Application reference; 20/03665/PLF

We wish the following to be well considered against the proposed new build plans on the plot situated North of 13 Hazel Avenue, Withernsea.

FLOOR LAYOUT PLAN
PROPOSED - SCALE 1:50

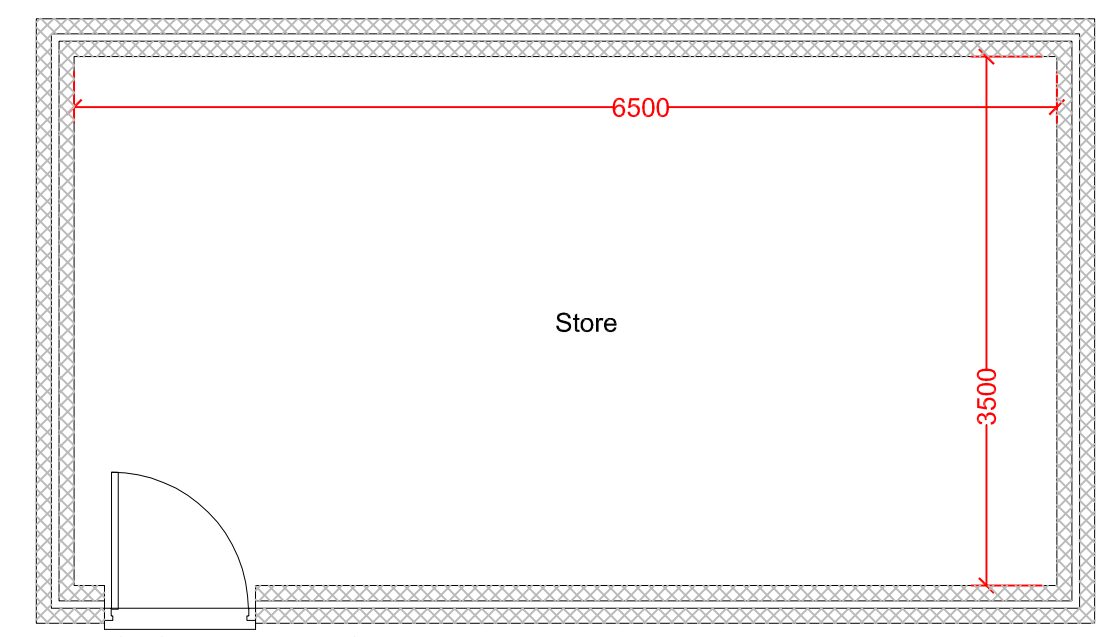
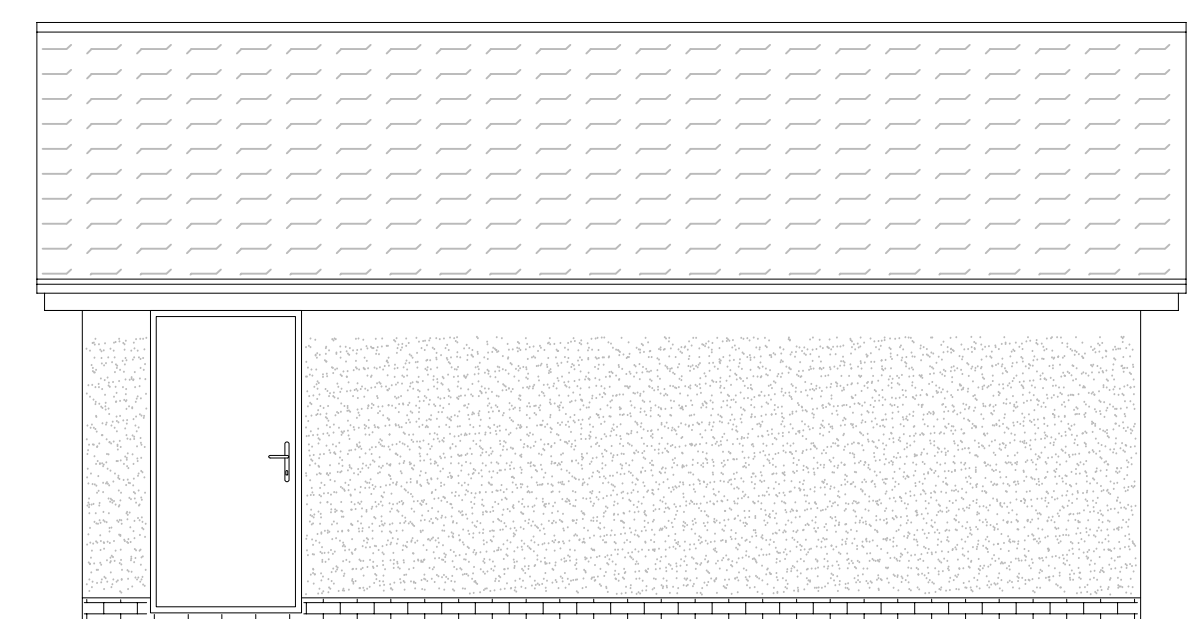
Carport or garage? We are baffled as to which definition is correct for this style of plan, as it would surely, mostly be an enclosed space? Wouldn't that make it a garage? The internal width at only

2900. Will this meet building requirements to call this 2 parking spaces? If so, an electric front door may be preferable to a key entry, to again be more inviting, and actively promote use of it.
